United Utilities Water Limited
Planning, Landscape and Ecology
2nd Floor, Grasmere House
Lingley Mere Business Park
Lingley Green Avenue
Warrington
WA5 3LP

Your ref: 3/2020/0465
Our ref: DC/20/2643
Date: 01-AUG-20

Location : Land adjacent to The Beeches 65 Whalley Road Langho BB6 8EF

Proposal : Outline planning permission for the demolition of an existing garage and the erection of

Illustrative Layout and Streetscape

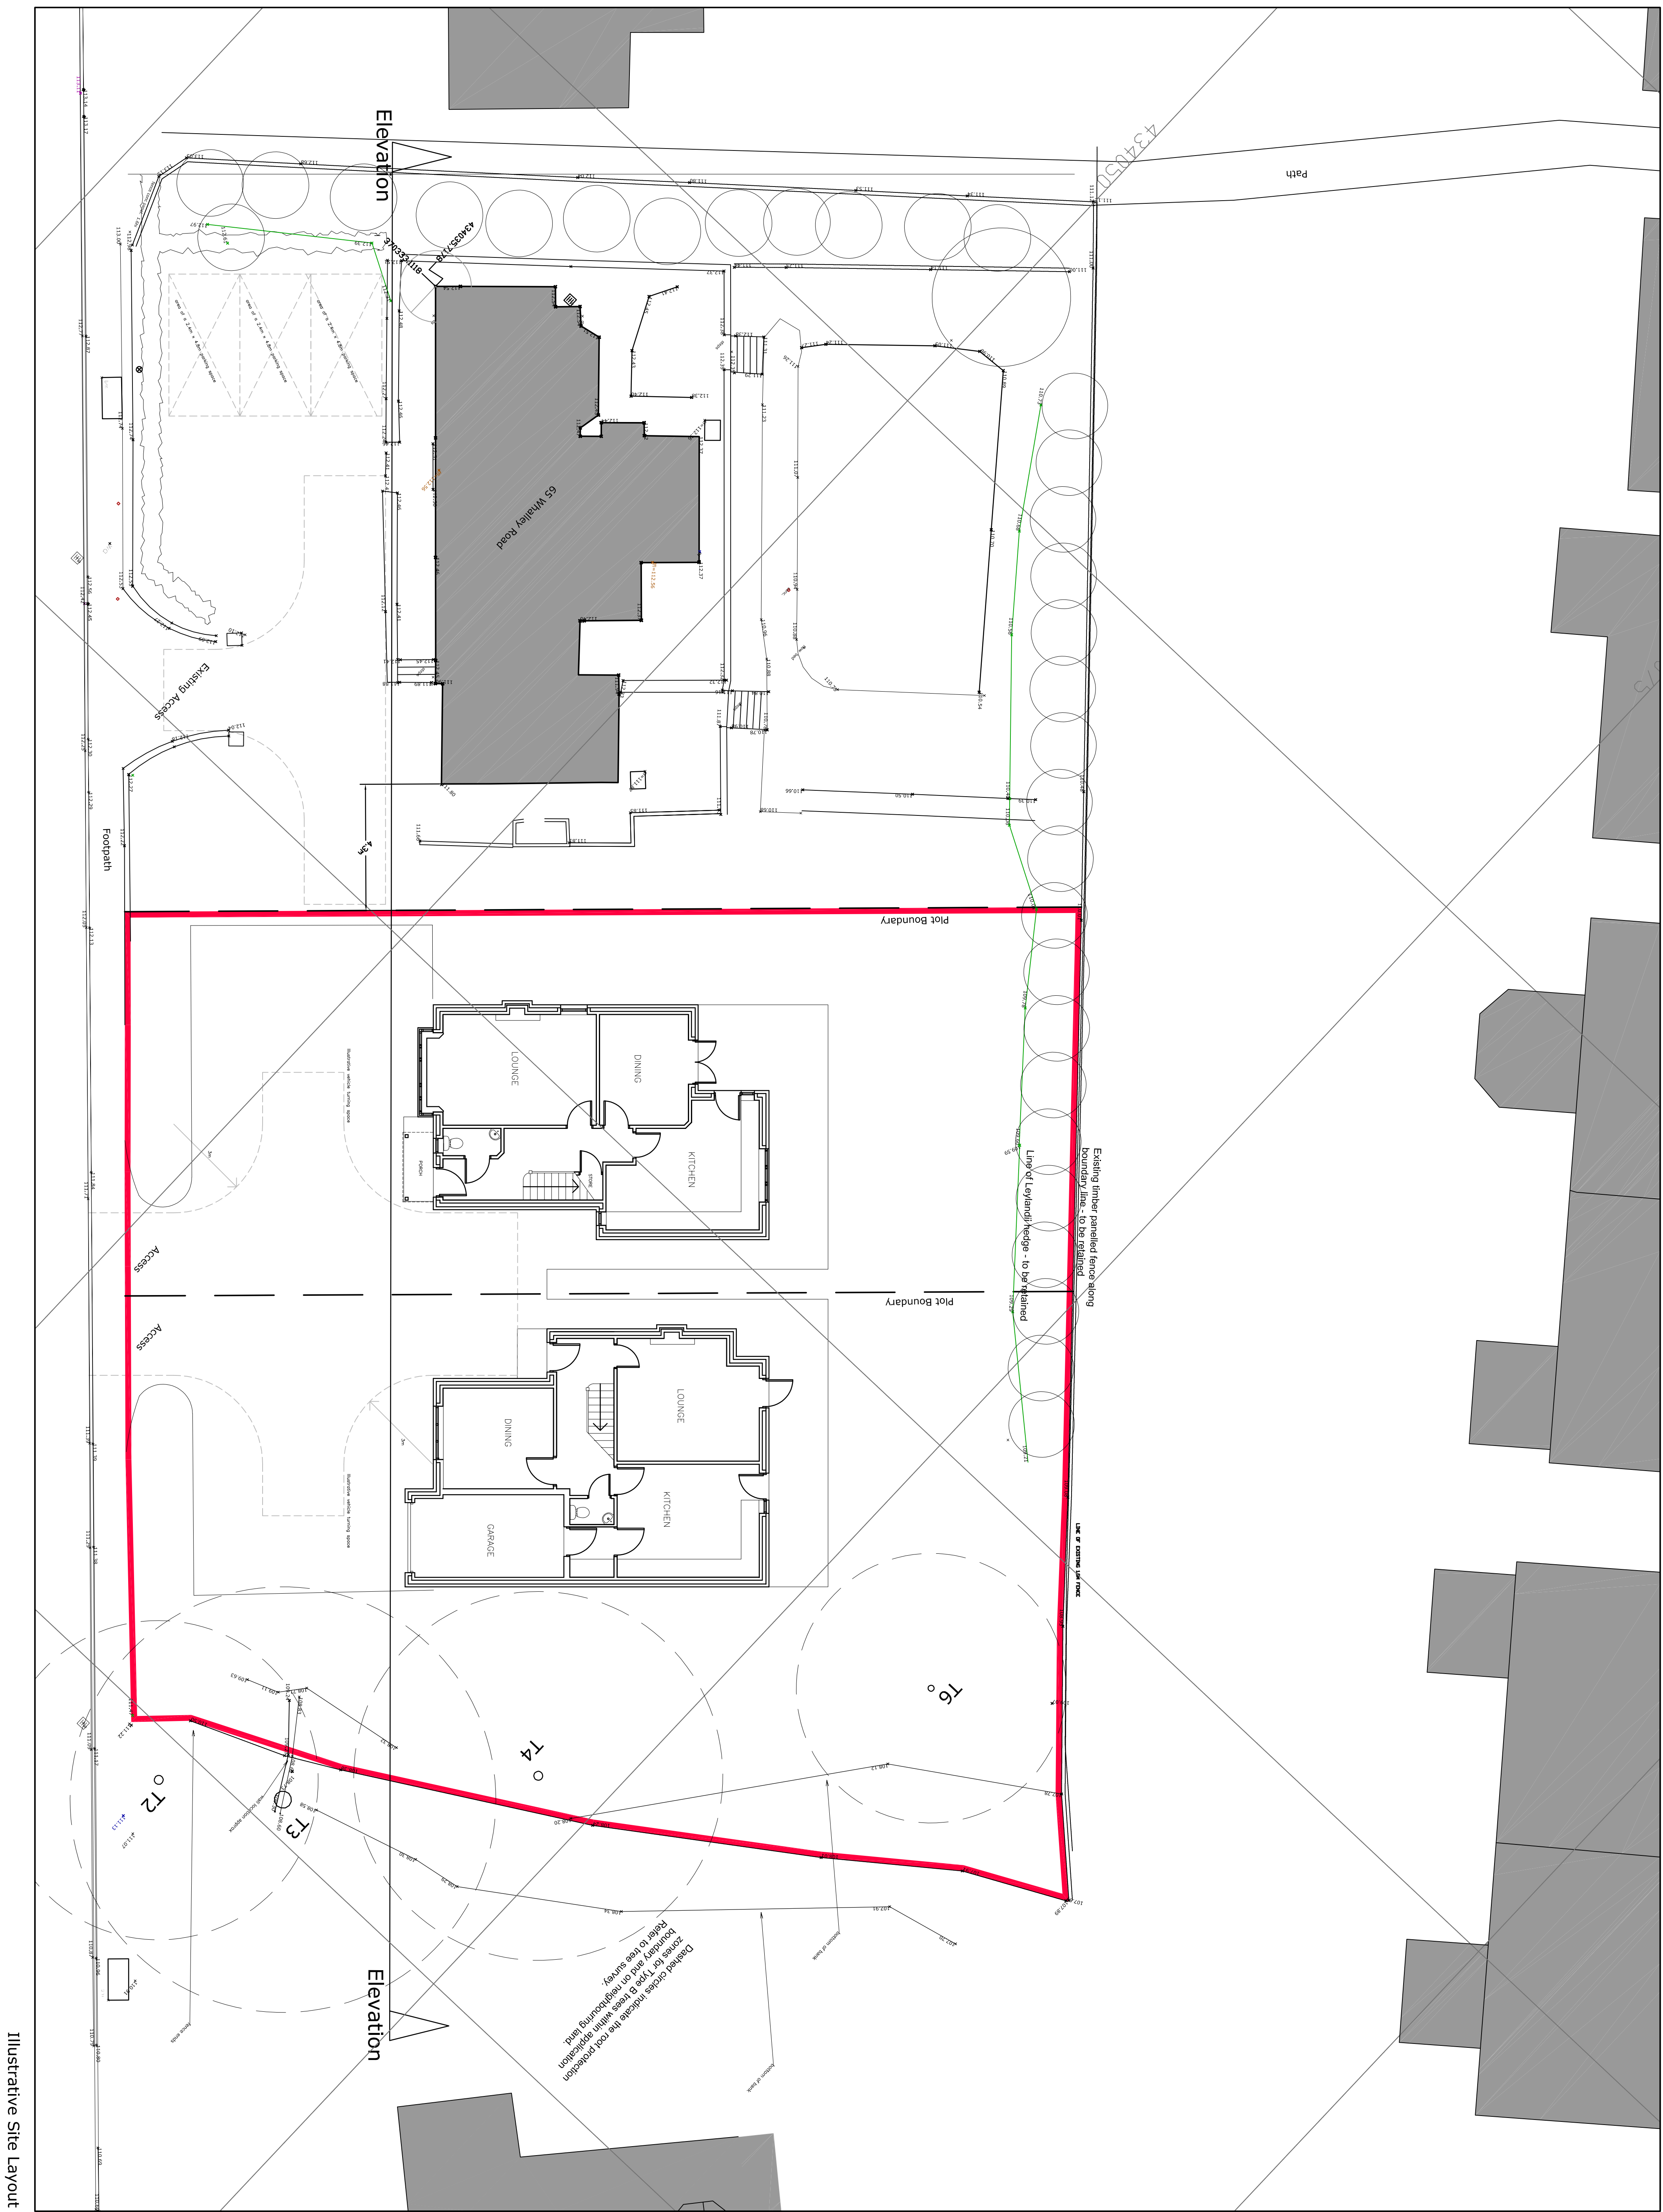
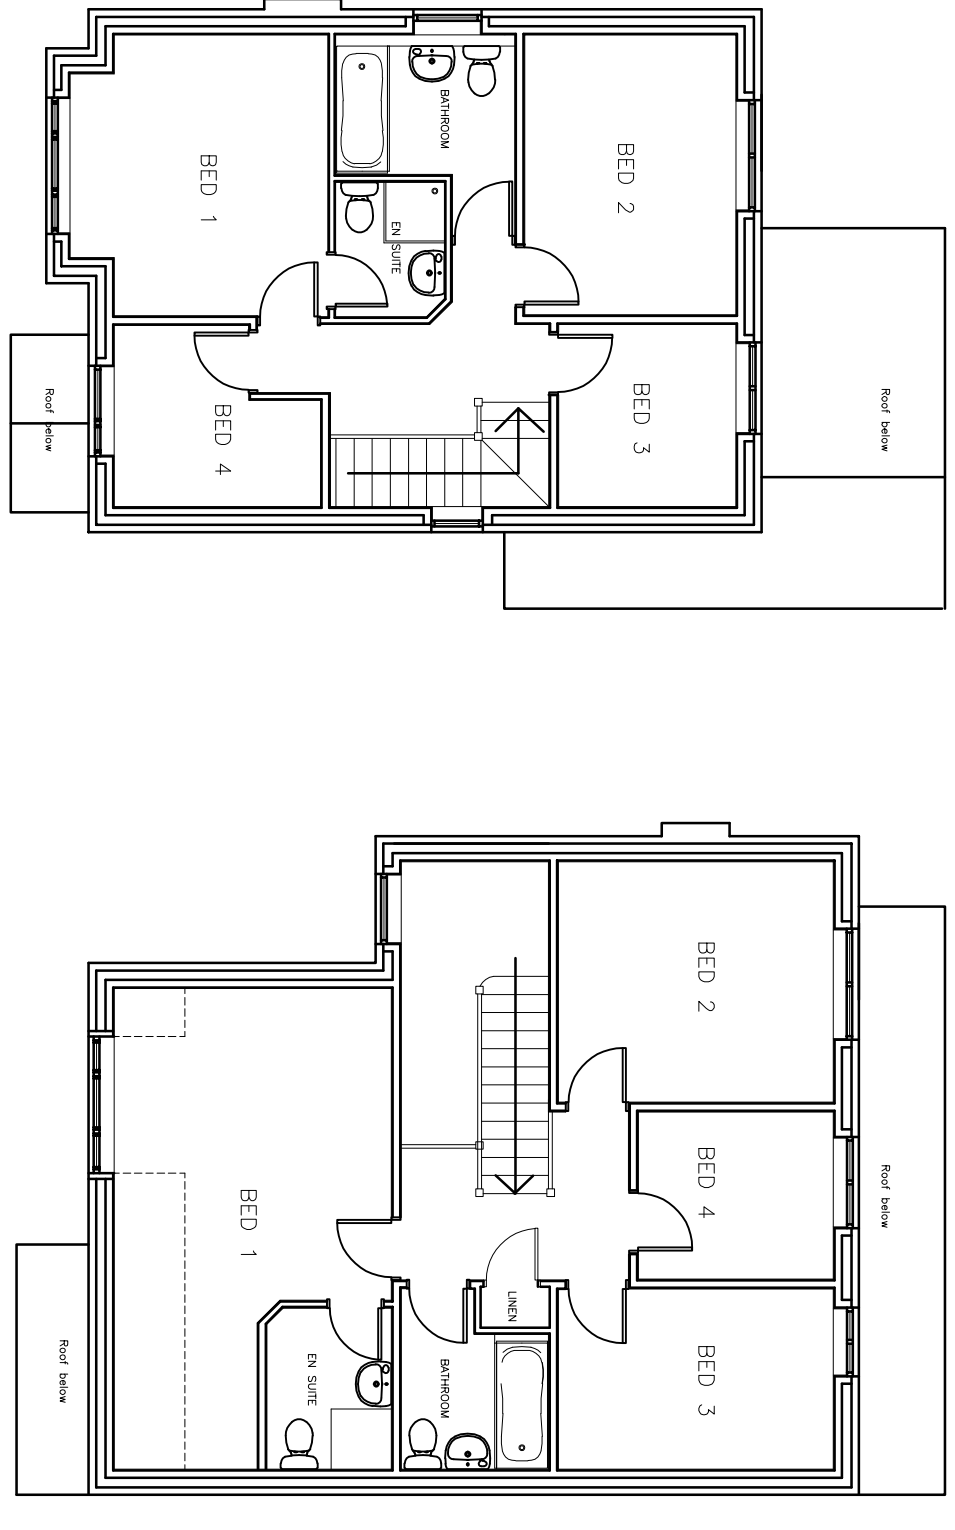
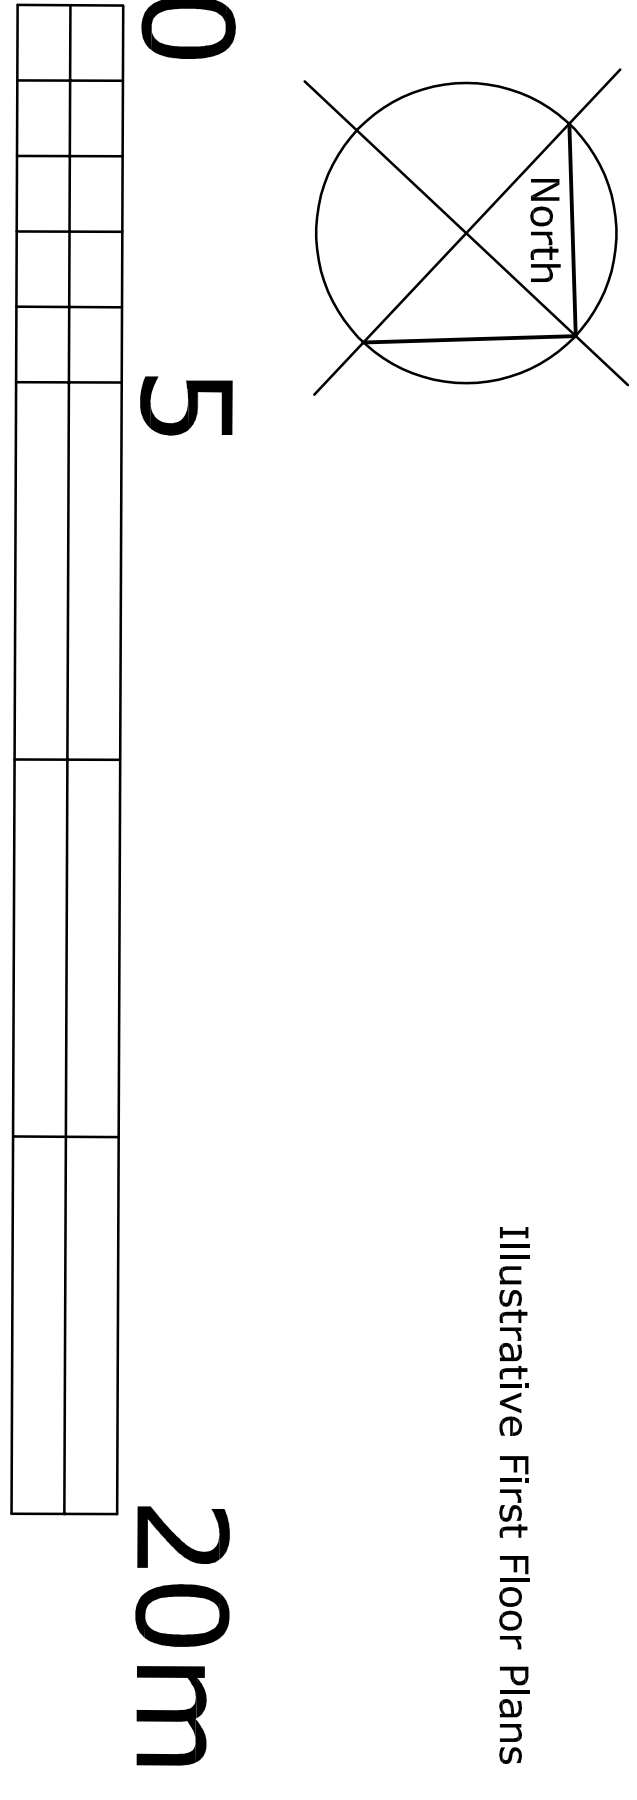
Also, based on the provided finished floor levels, there is a potential for new hydraulic lows to be created and therefore mitigation such as non-return valves or a pumped solution maybe required. The applicant should consider the drainage levels and the potential mitigation as no development will be acceptable where new hydraulic lows are created.
